OUT19/10712

**Maxwell Underground Coal Mine Project (SSD-9526)
EIS Exhibition**

DPIE Water Group and the NSW Natural Resources Access Regulator (NRAR) have reviewed the EIS.

Detailed advice to DPIE Planning & Assessment regarding the Maxwell Underground Coal Mine Project (SSD-9526)

Swamp Oak Forest
 - Saddlers Creek (North)

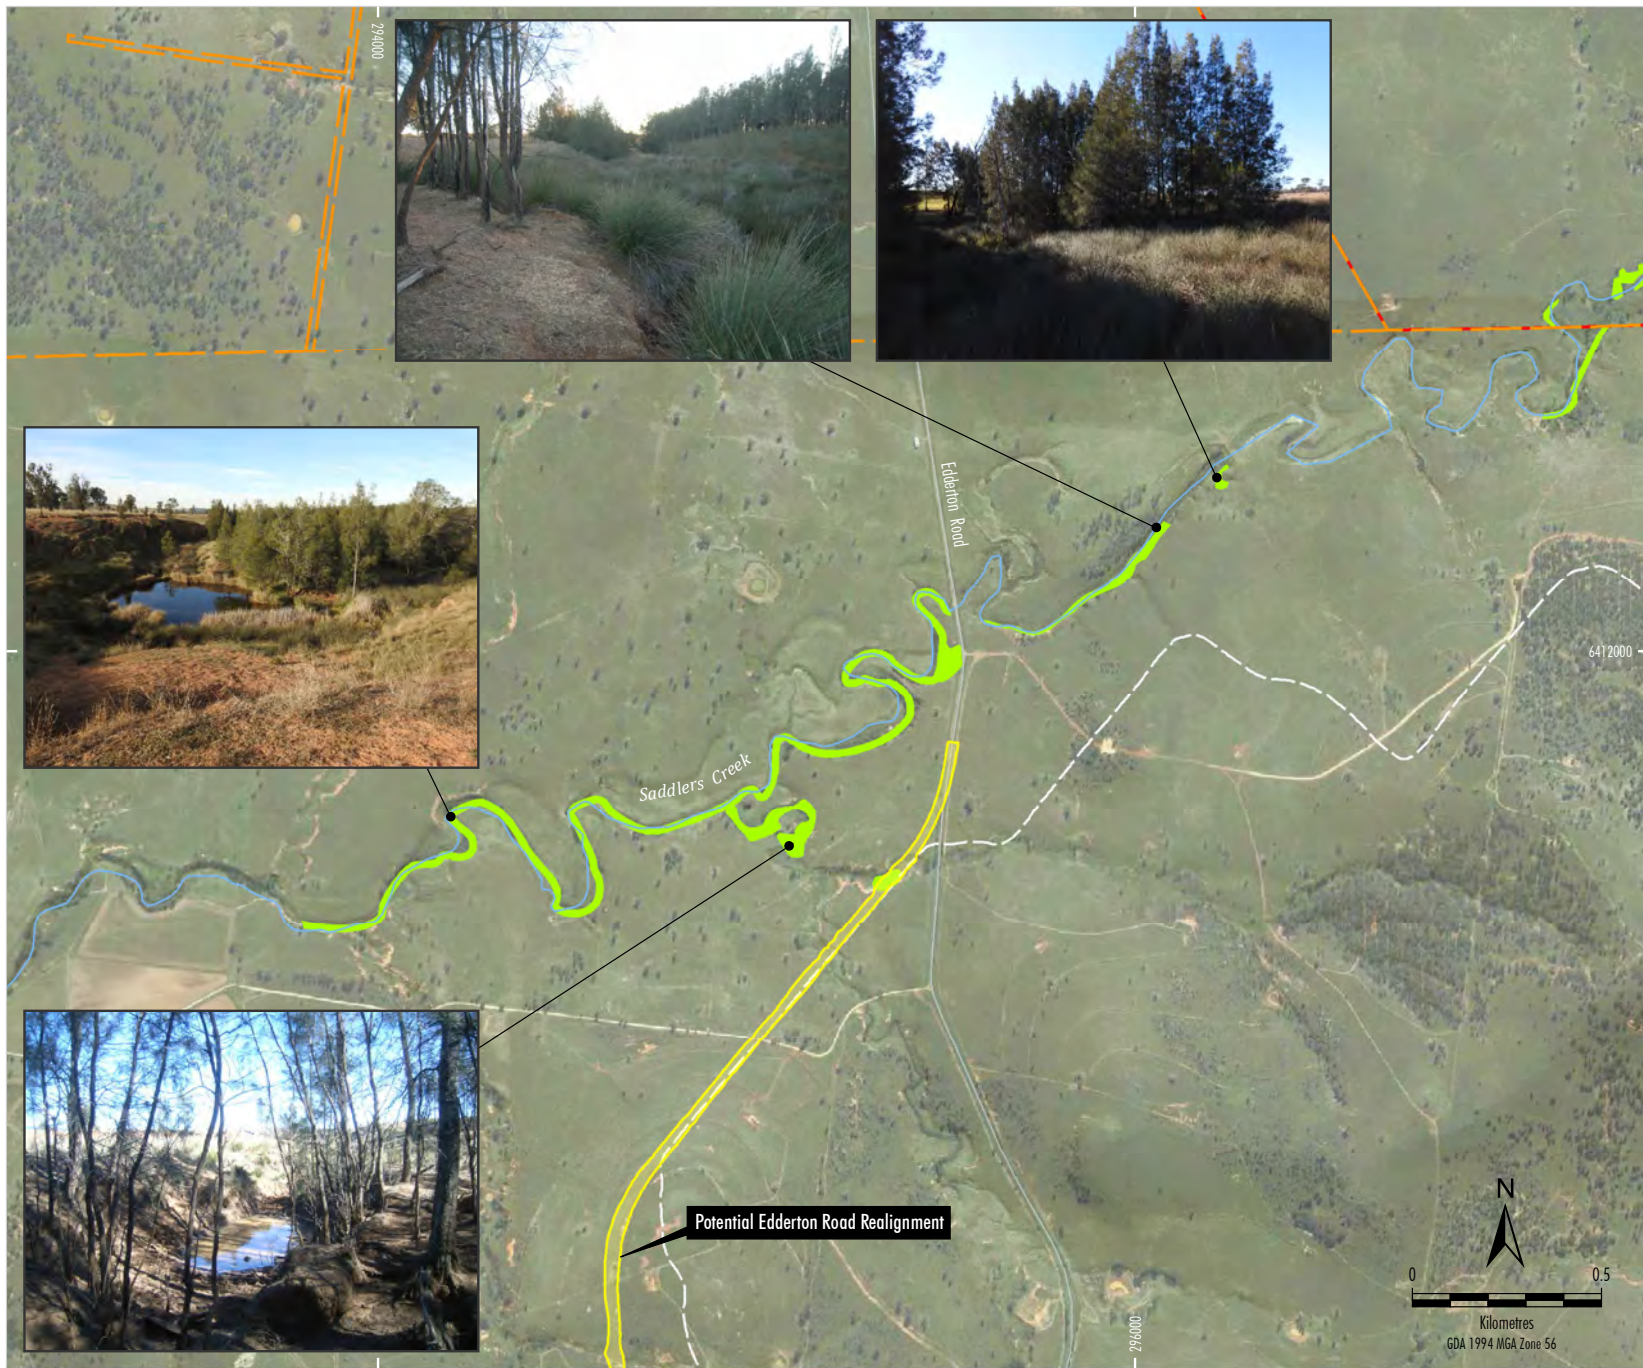
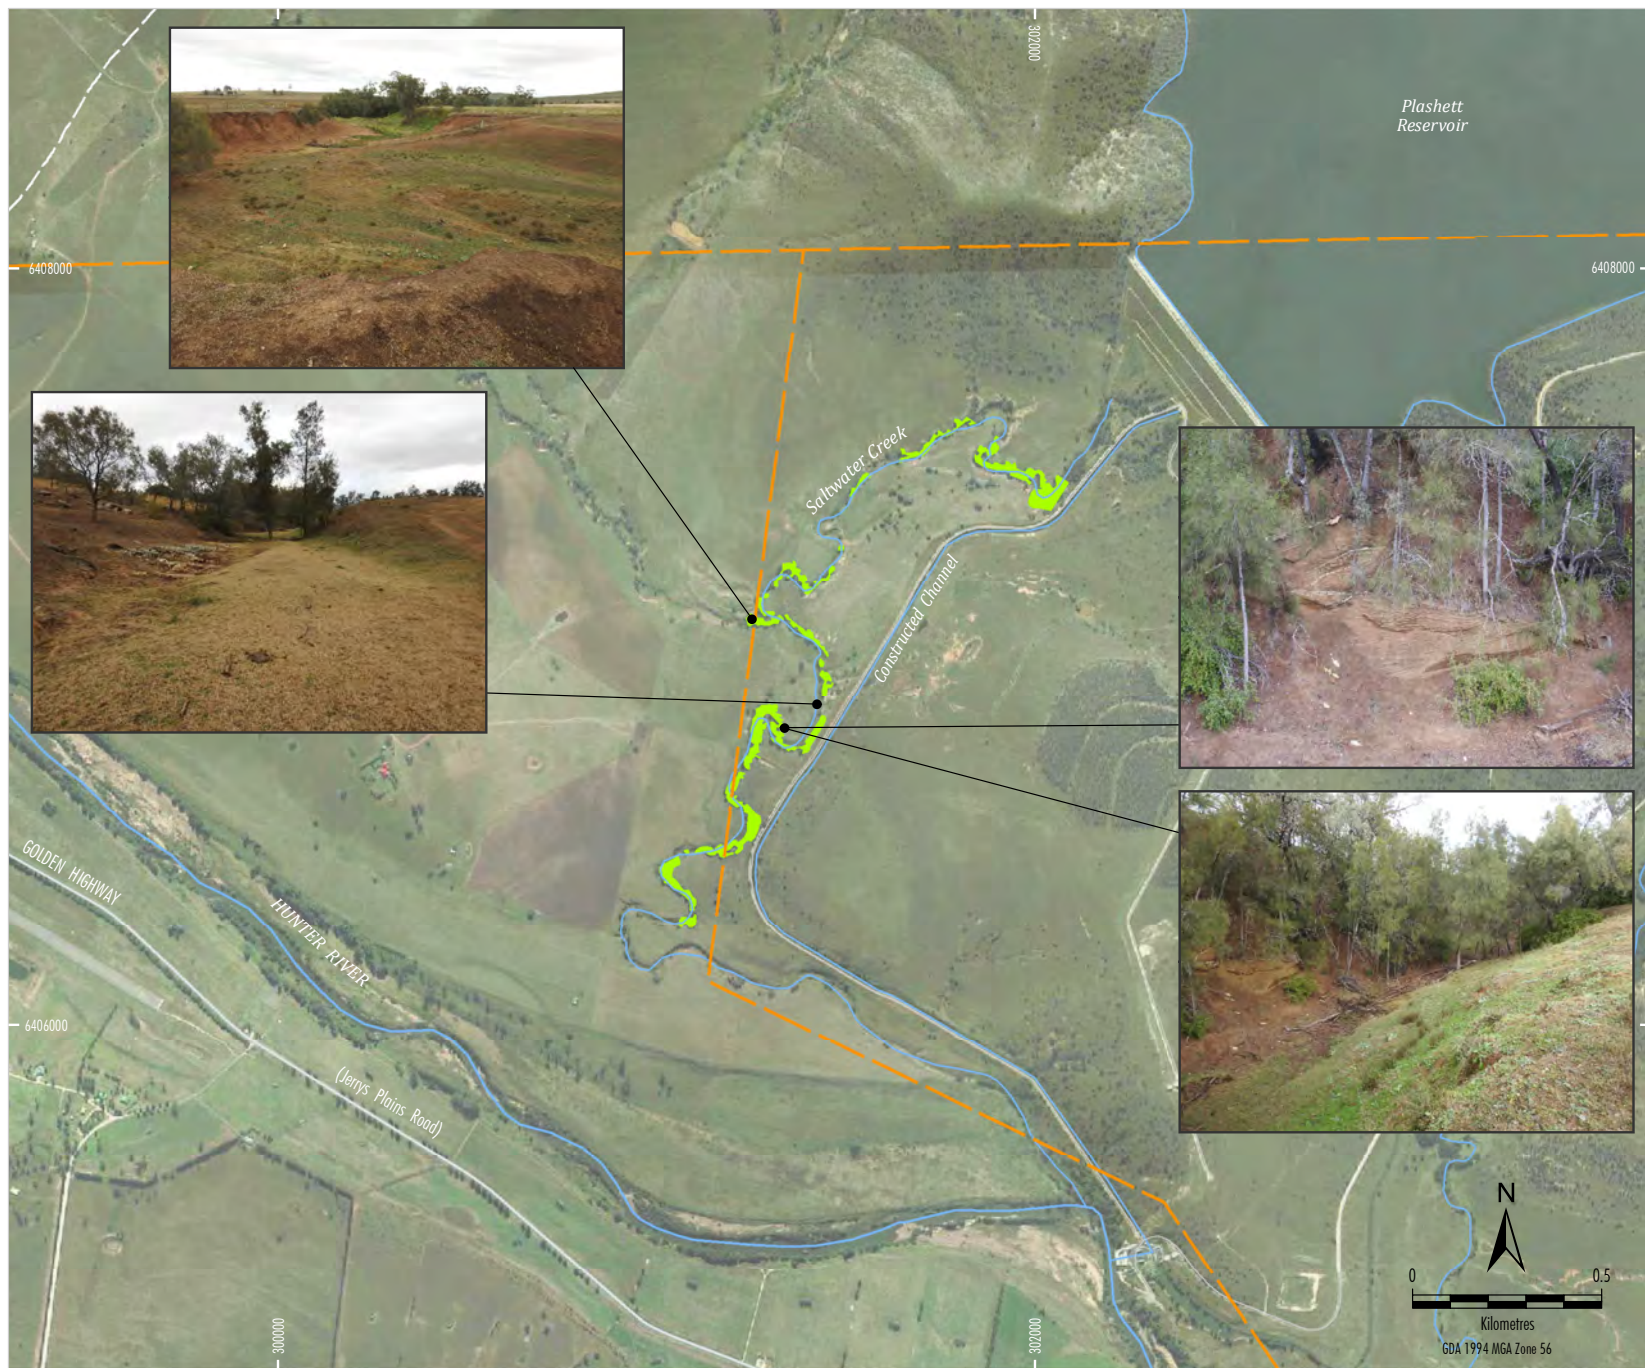
No 'high priority' Groundwater Dependant Ecosystems (GDEs) or culturally significant sites are located in proximity to the Project. However, a potential GDE (Swamp Oak) community has been

identified along Saddlers Creek. This community should be considered for monitoring as part of the on-going environmental monitoring requirements.

DPIE Water recommends that the proponent commit to monitoring the condition (including baseline) of the potential GDE (Swamp Oak) identified along Saddlers Creek.
